Please ask for: Sian Eggington
Email: sian.eggington@terraquest.co.uk
Telephone: 0121 2341390
Our Ref: R/107/20/HH
Your Ref:
Date: 22nd June 2020

Application for Planning Permission for Works or Extension to a Dwelling

Development: Proposed front dormer alterations
Location: 25 Sea Avenue Rustington BN16 2DQ

SITE LOCATION PLAN
1:1/250

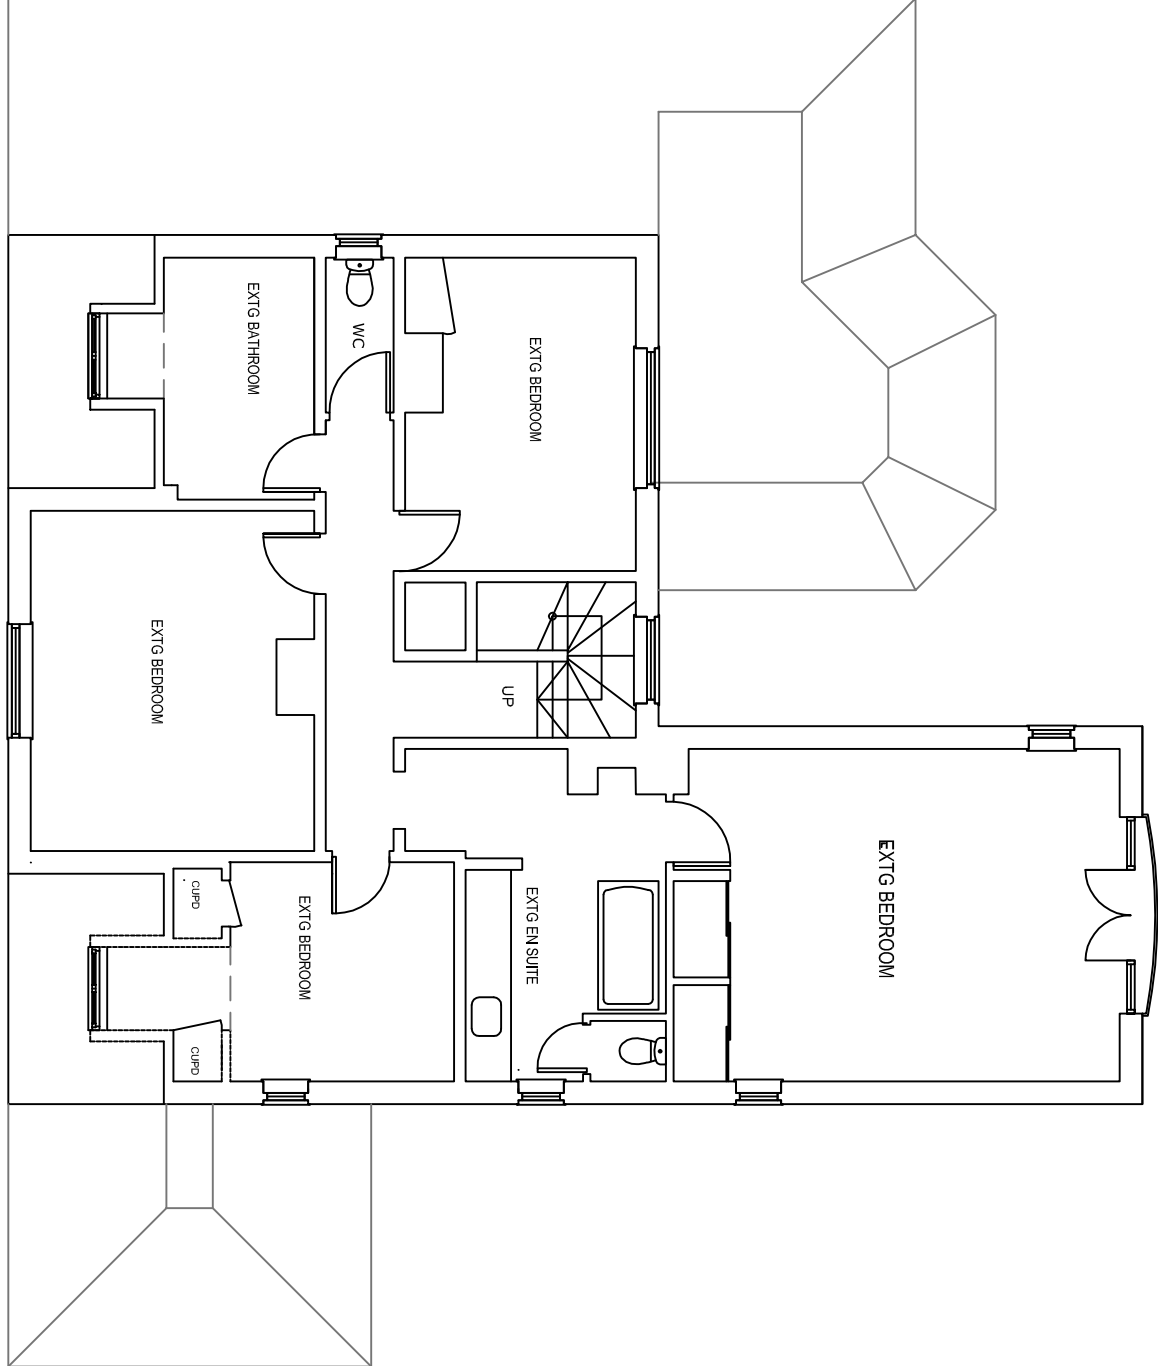
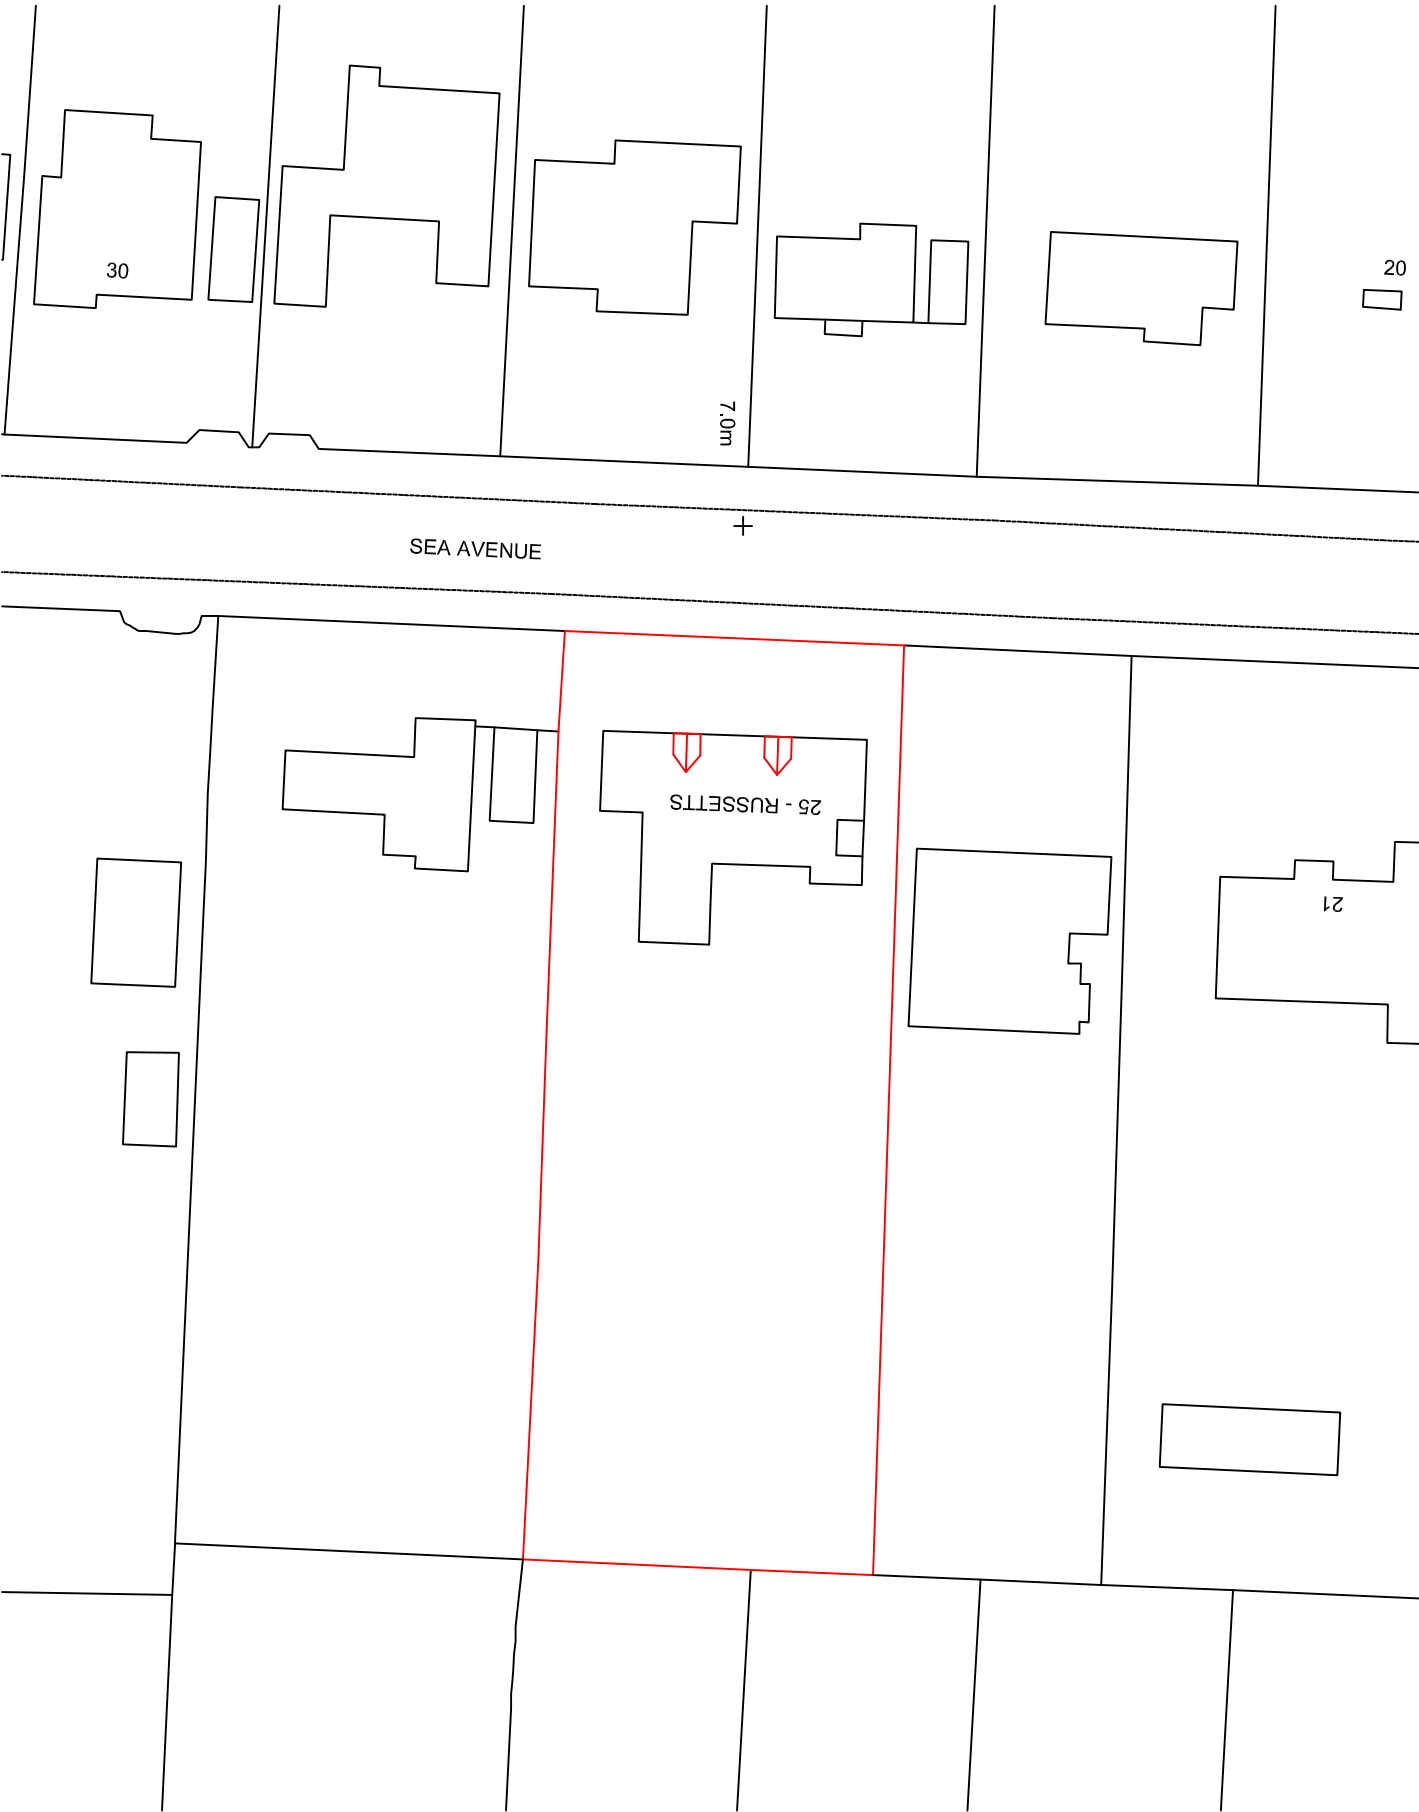
Location Plan: The red outline on the location and block plan crosses over into the neighbouring boundary. Please amend.
